APA Reference: 20180424_LO_439701_Renew Estate Bomen Solar

NSW Department of Planning & Environment

RE: **Proposed development of Bomen Solar Farm**
State Significant Development Application Number SSD8835

Figure 1.2 - The Proposal

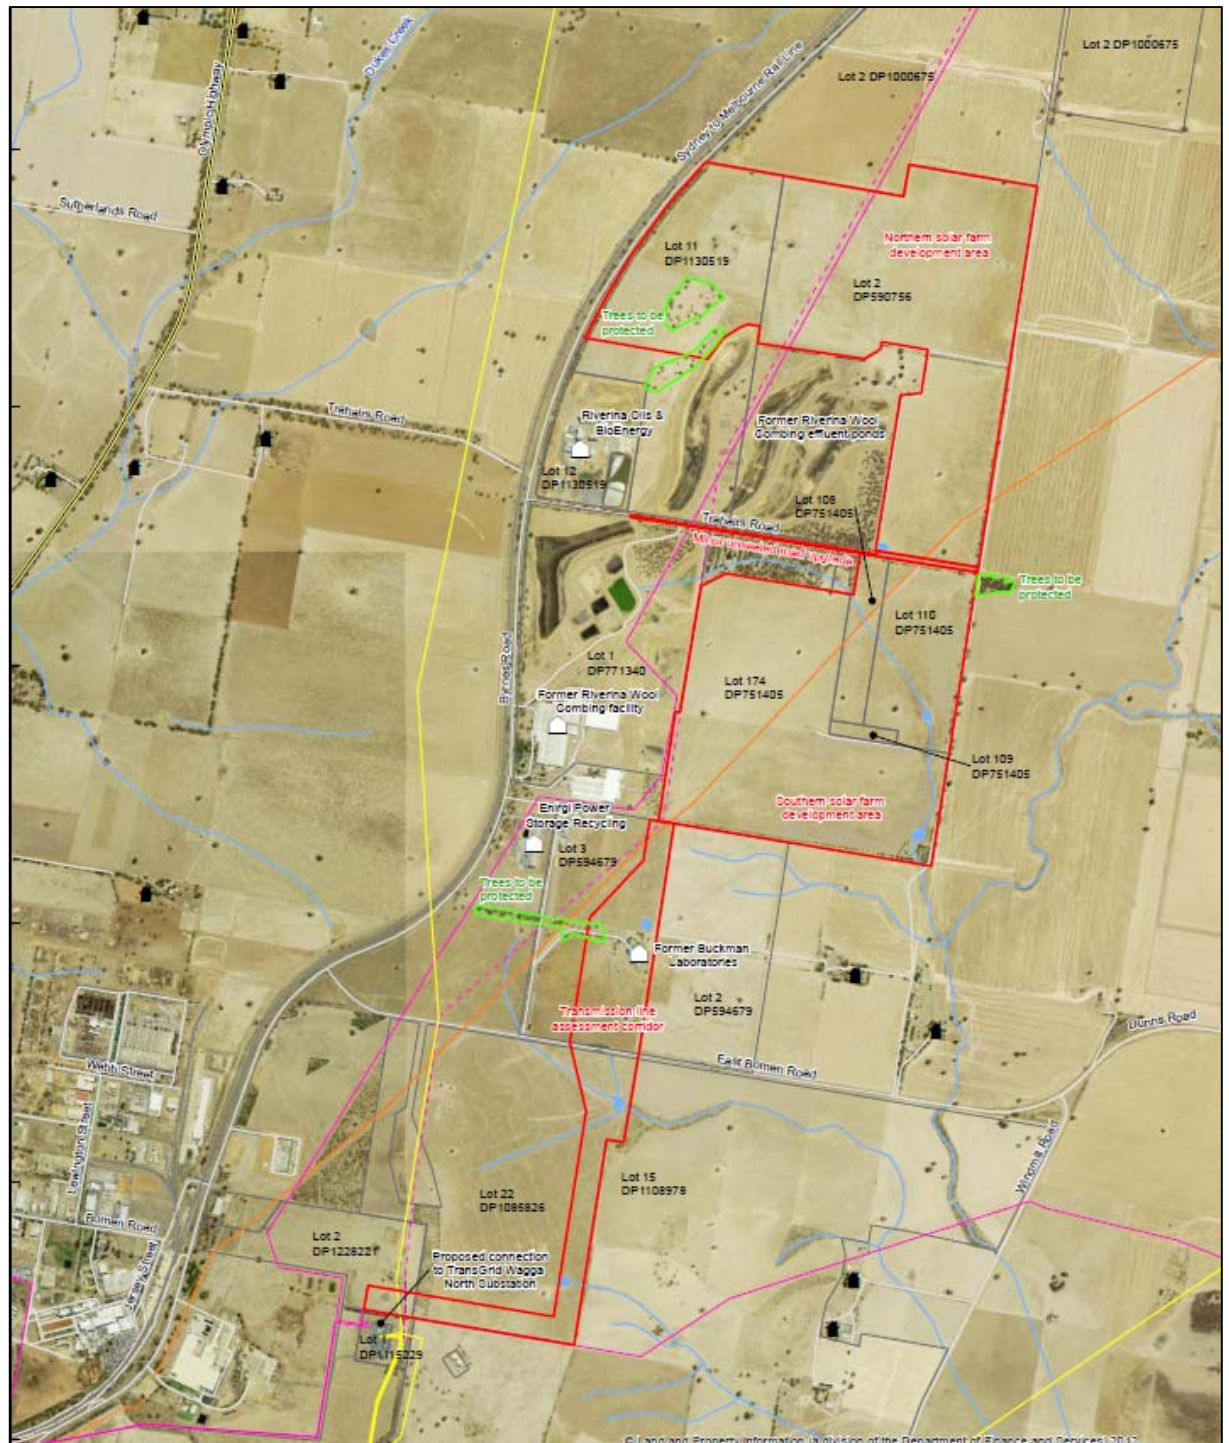
The proposal plan clearly shows APA’s pipeline and easement, however does not accurately label it as a ‘high pressure gas transmission pipelines’. The easement is clear of the siting of solar panels, although panels are shown up to the boundary of the easement.

The proposal plan shows Trahairs Road crossing the pipelines, to access the proposed hardstand compound area and control building, where the road ends. While the road exists, it appears to be only a minor access road and does not carry through traffic.

The proposed development has significant areas of panels to both the east and west of the pipeline easement. A single area for both potential battery storage and substation is located to the west of the development site. Regardless of the final area for battery storage and substation, the need for crossings of the pipelines is anticipated. These are expected to include:

- Electrical feeder lines (either above or underground) to transformers and the on-site substation
- Electrical transmission lines from the substation to transmission grid connection point
- Access tracks (for construction and operation).

APA seeks to minimise the number of crossings and have these perpendicular to the pipelines if possible. No work on the easements, including crossings, changes in ground level or other works, may occur without the prior authorisation of APA. Detailed design for crossings will need to be informed by field works to positively locate the pipeline (alignment and depth). Such field works must only be performed under APA permit.

Details of all proposed crossings, and works within the easement, must be submitted to APA for consideration. No crossings may occur without the prior authorisation of APA, and must be completed in accordance with any conditions imposed by APA. This includes the existing location of the Trahairs Road crossing.

All plans which include the area of the gas pipeline easement must have the easement clearly identified with hatching on the full width of the easement. The easement must also be clearly labelled as *'high pressure gas pipeline easement – no works to occur without the prior authorisation of the pipeline operator'*.
